Recommendation Report for Planning Permission for Works or Extension to a Dwelling

REF NO: LU/406/21/HH

LOCATION: 84 Oakcroft Gardens
Littlehampton
BN17 6LU

PROPOSAL: Proposed rear and side single storey extensions, alterations to existing first floor dormers and installation of 1 No. Velux rooflight.

PROPOSED EAST ELEVATION 1:50

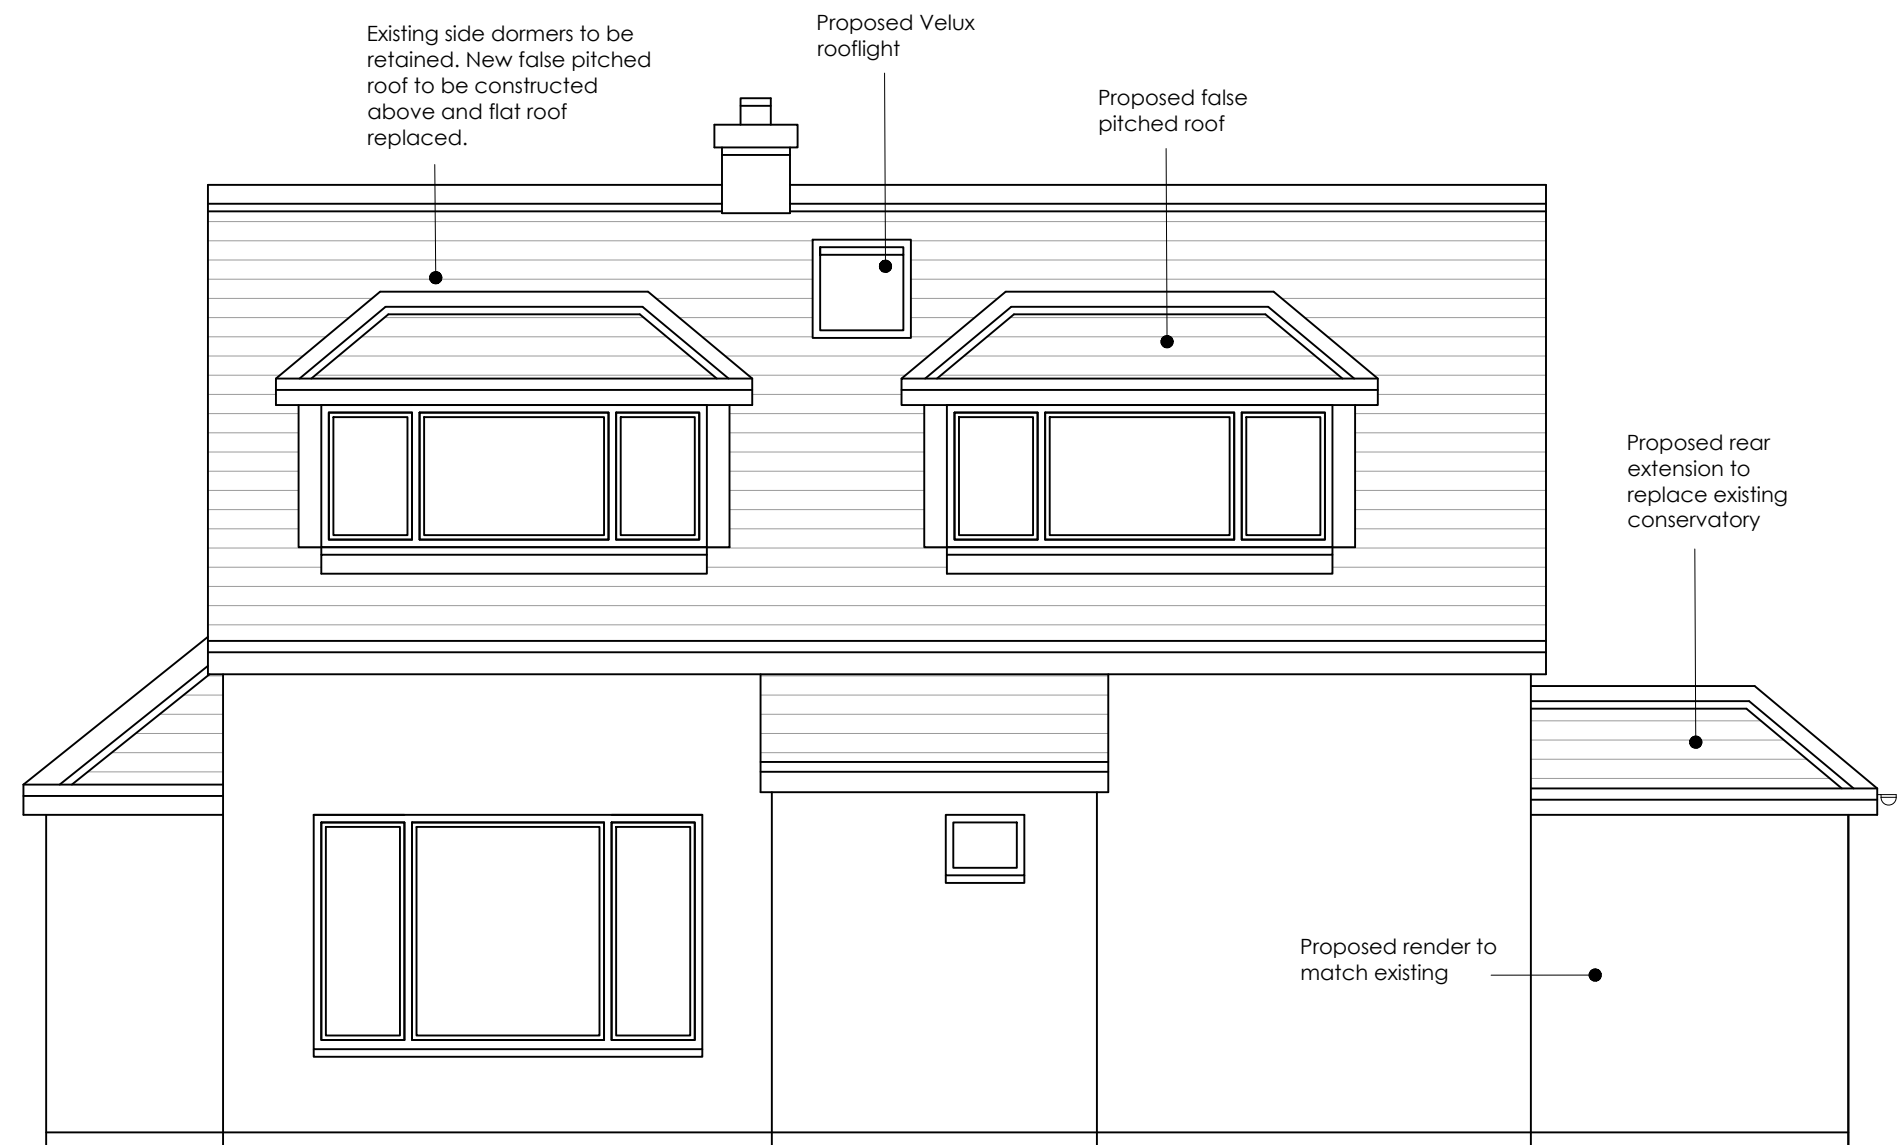
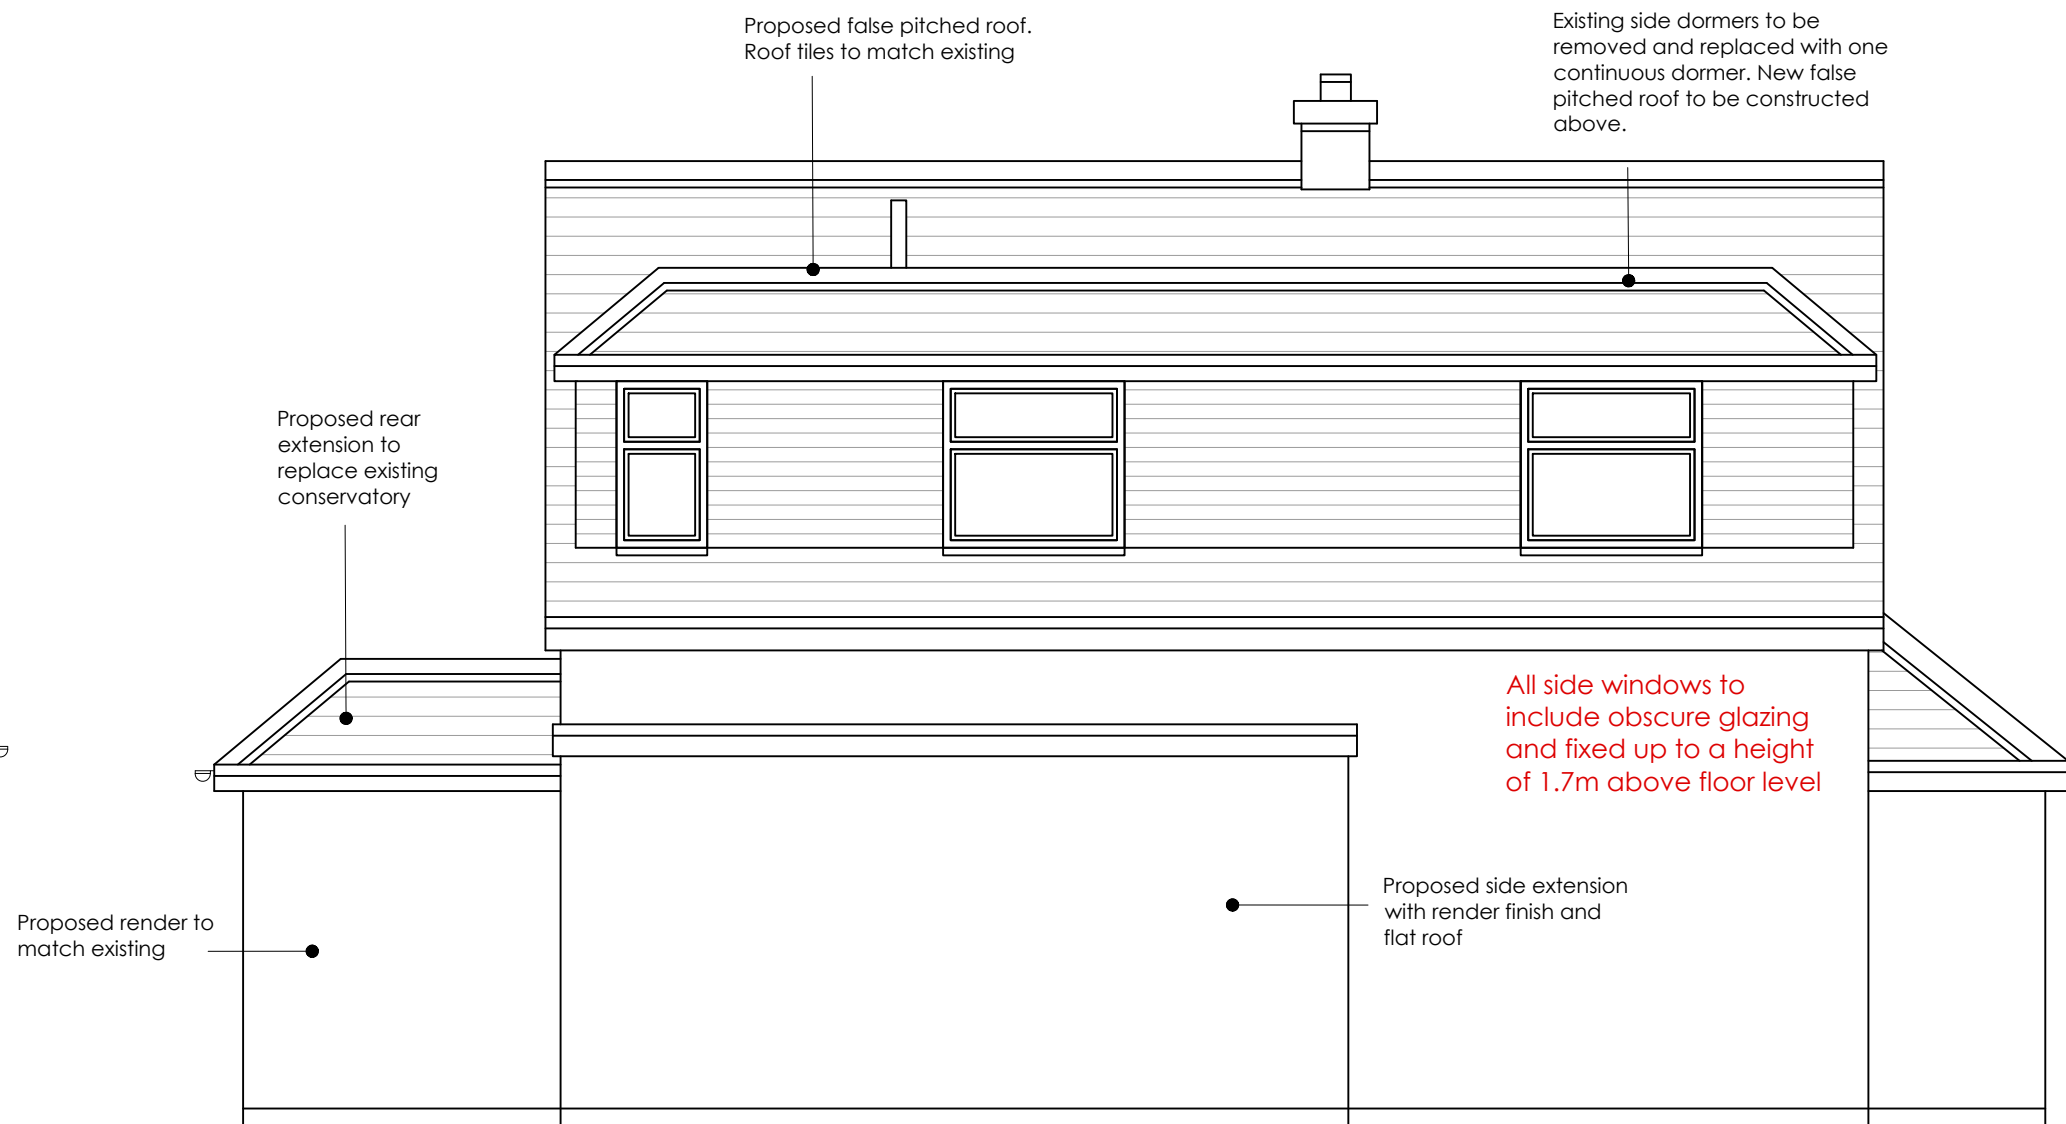
The single storey rear extension makes efficient use of the existing conservatory footprint but does extend 0.4m further to the rear of the property than the existing built form. This component extends 7.29m across the rear elevation from the east elevation to the western site boundary, maintaining the width of the existing conservatory/toilet. The rear extension features a false pitched roof design that meets the rear elevation at a height of approx. 2.9m, an approx. 0.1m increase. The rear extension incorporates matching materials to those found on the dwelling, is visually integrated and sympathetic to the host dwelling in terms of form, scale and design. There are no views of this component from the street.

The single storey side extension is 1.25m in width, projecting off of the western elevation and meeting the western site boundary. The side extension is 7.31m in depth, extending down the side (western) elevation, meeting the proposed rear extension. This component features a flat roof design at approx. 2.6m in height and matching materials to those found on the existing dwelling. It is predominantly obscured from view by the host dwelling and neighbour dwelling to the west. There are potential views from the street but the scale and design are appropriate and do not give rise to adverse visual impacts on the street scene.

The alterations to the flat roof dormers include false pitched roof designs and replacement of 2 No. western elevation dormers with 1 No. large dormer. Proposed alteration of the dormers to feature false pitched roofs is considered a complimentary design choice being sympathetic to the existing roof pitch and furthering visual integration. The 2 No. eastern dormers do not give rise to any adverse visual

impacts on the street scene. The removal of the western elevation dormers and replacement with one large dormer is not considered sympathetic to the host dwelling in terms of scale. It is acceptable as it is visually integrated through design, choice of materials and not being out of character within its locality as the locality is populated by large first floor dormers. The western elevation is partially obscured by the neighbour dwelling to the west and as such, has reduced visual impacts on the street scene.

The rear extension includes rear glass doors that look to the rear of the property, retaining 11m to the rear boundary. The scale of the rear extension is moderate and makes efficient use of the existing conservatories built form. Section M of the Arun Design guide sets out the 45 & 60 degree sightline rule when concerning rear extensions. The rear extension component does not obstruct 60 degree sightlines from rear the rear viewpoints of any neighbouring dwellings. The rear extension also, does not obstruct neighbouring 45 degree light access lines. This component does not give rise to any adverse impacts by way of overbearing, overshadowing or overlooking.

The side extension meets the western site boundary. This is in close proximity to the eastern elevation of the neighbour dwelling 83 Oakcroft Gardens. There is a path extending down the eastern elevation of 83 Oakcroft Gardens and 2 No. side facing windows that look over this path and at the western elevation of 84 Oakcroft gardens. The side extension will extend approx. 3m alongside this pathway but not significantly adversely impact the viewpoints from these side windows. The viewpoints these neighbouring windows currently possess are already met by the Western elevation of the host dwelling and provide lookout to little more. The larger of the 2 No. windows on the east elevation of 83 Oakcroft Gardens is closer to the front of the dwelling and will still retain the partial existing view that is able to look past the front of 84 Oakcroft Gardens at an angle to see the street. The side extension may have some minor adverse impact by way of overbearing on the eastern elevation of 83 Oakcroft Gardens however, it will not give rise to any significant loss of light or obstruct any significant sightlines for these neighbouring windows further than what is already achieved by the existing host dwelling. This component is acceptable.

The new west facing dormer has been proposed to have obscure glazed windows that are fixed shut up to 1.7m. This is appropriate due to the sightlines they provide, looking out onto the side of the neighbouring properties. As such, in concurrence with the submitted plans, these have been conditioned to be obscure glazed and fixed shut up to 1.7m

Reason: For the avoidance of doubt and in the interests of amenity and the environment in accordance with policy D DM1 of the Arun Local Plan.
- 3 The proposed west facing dormer in this application hereby approved, shall have non-opening windows below 1.7m above floor level. The dormer windows will also be fully obscured prior to the first use of the rooms.
